Please ask for: Ms Iqraa Malik
Email: iqraa.malik@terraquest.co.uk
Telephone: 01212341390
Our Ref: EP/101/21/HH
Your Ref:
Date: 20th August 2021

Application for Planning Permission for Works or Extension to a Dwelling

Development: Erection of single storey rear, part two storey side and front porch extension
Location: 35 Roundstone Crescent East Preston BN16 1DG

Project:	
Proposed extension; 35 Roundstone Crescent, East Preston BN16 1DG	
Drawing:	
Plans and elevations as existing	
For:	
Mr. P. Windsor & Ms. A. Finch	
Drawn:	Date:
PKS	June 2021
Scales:	No:
1:100 1:200	2743/01/01
To scale when printed on A3

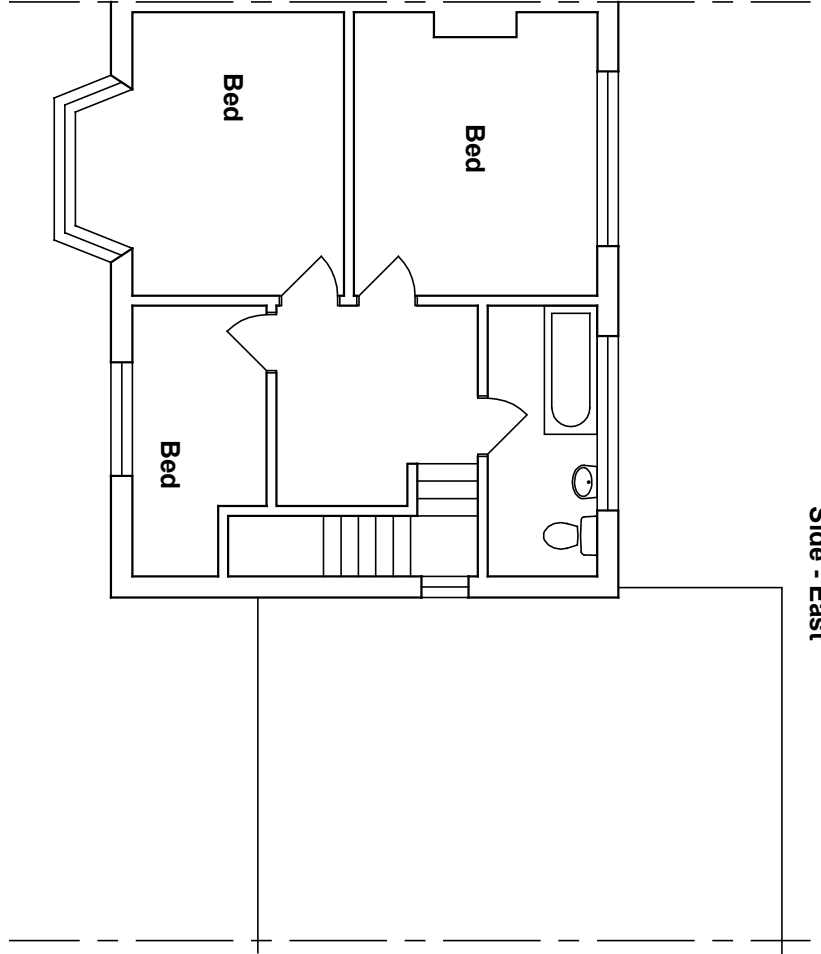
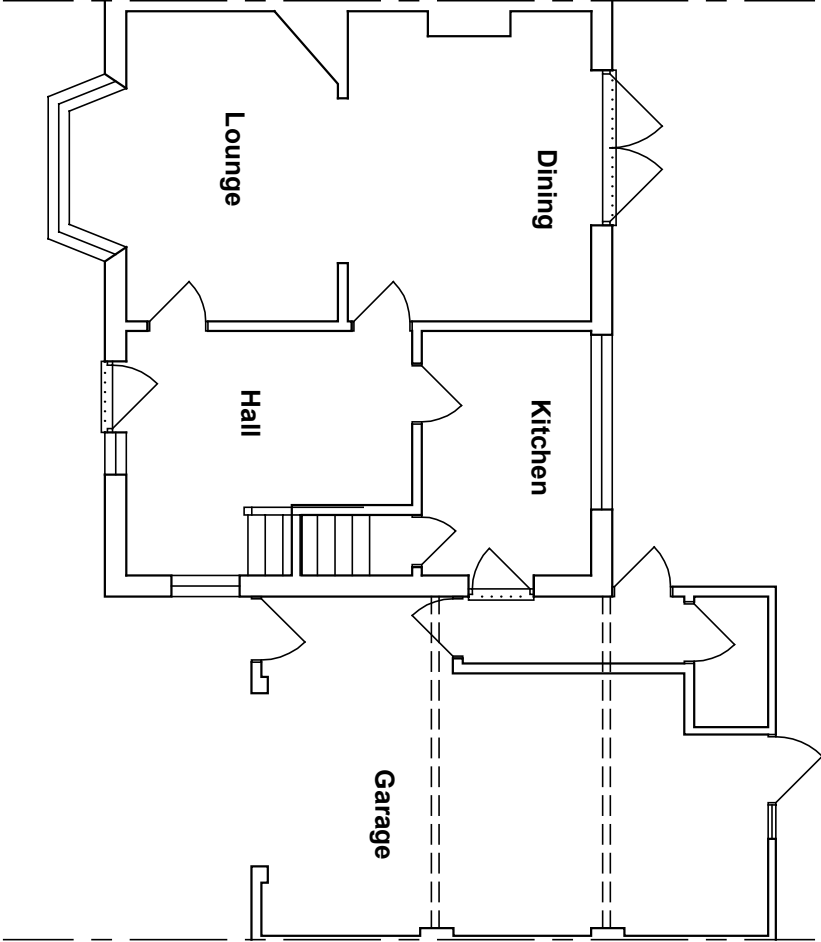
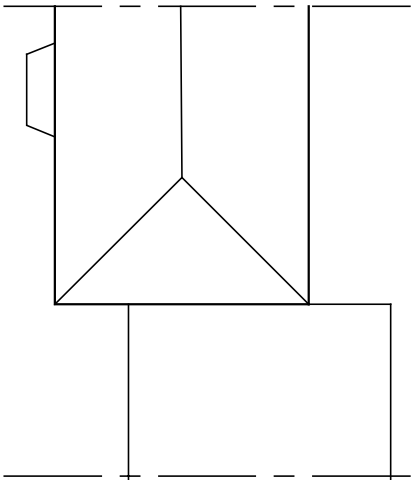
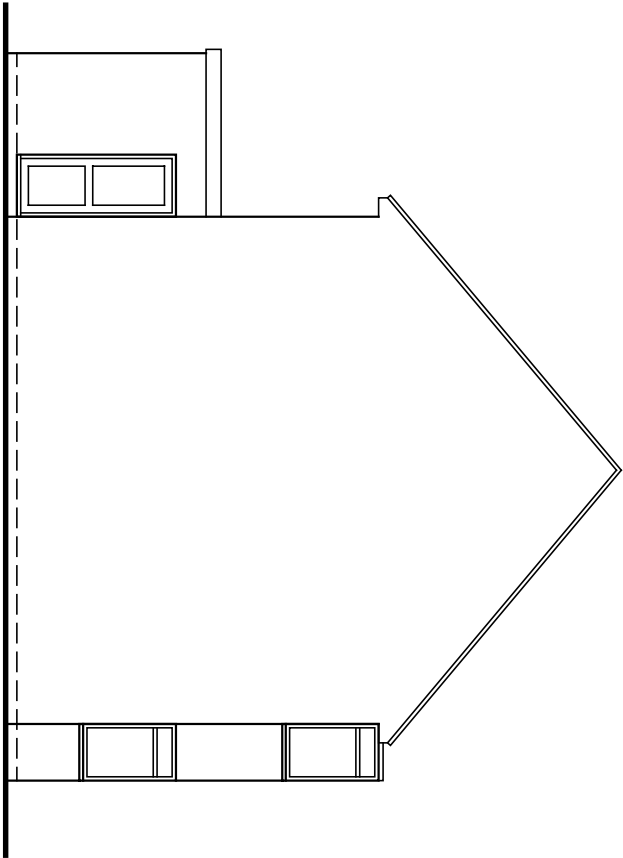
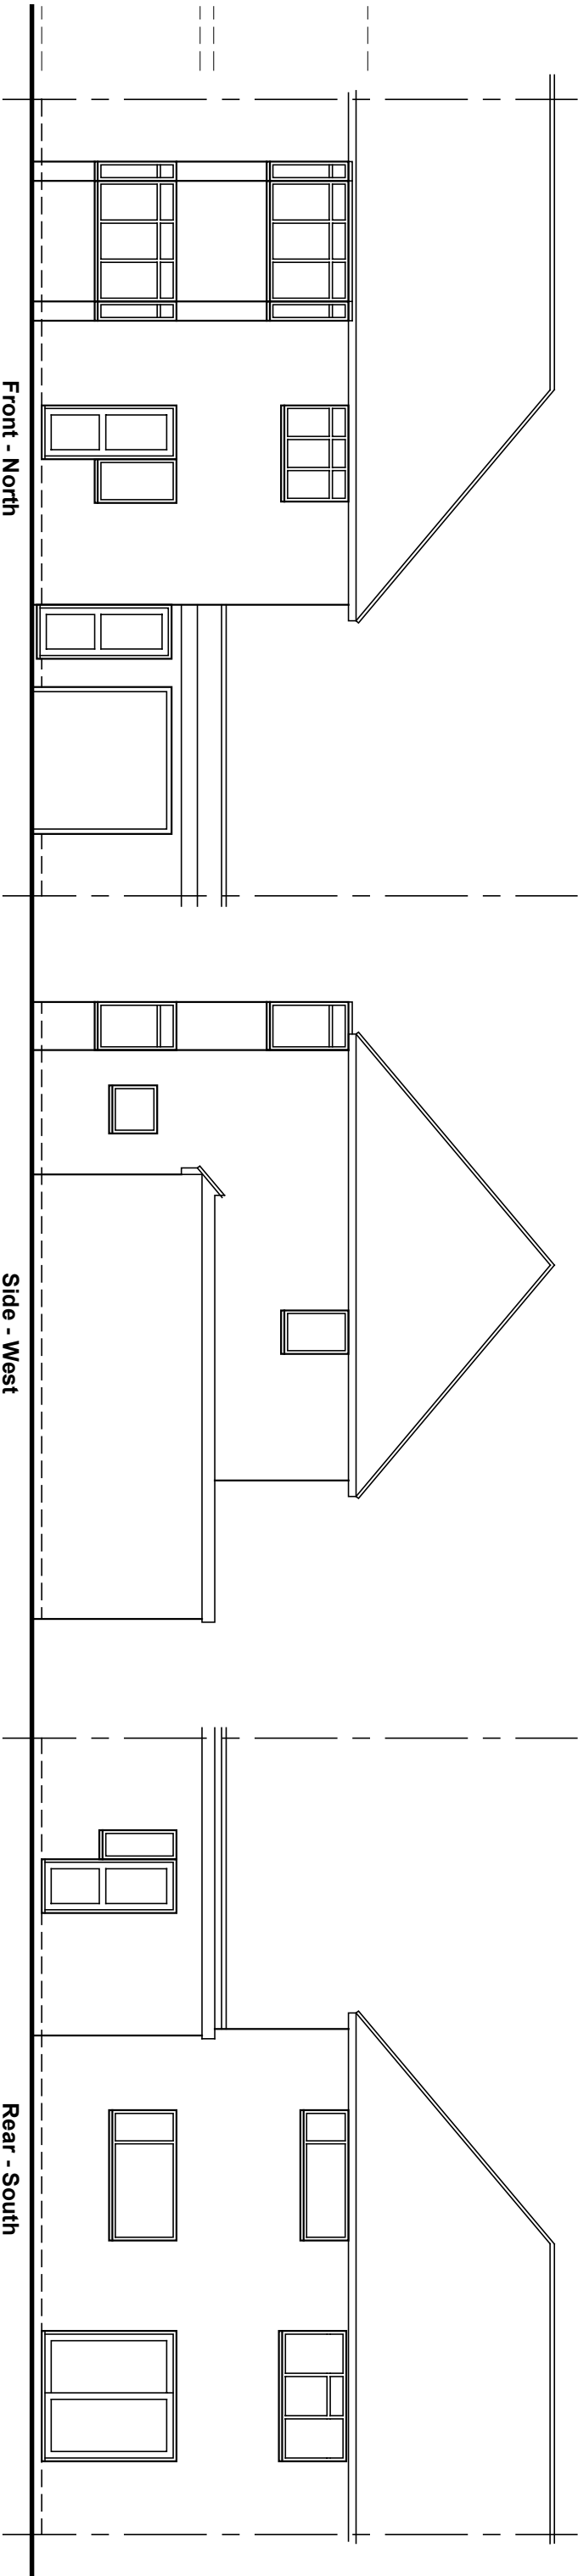
The door on the existing ground floor plan is missing from the existing side - east elevation. Please review and amend.
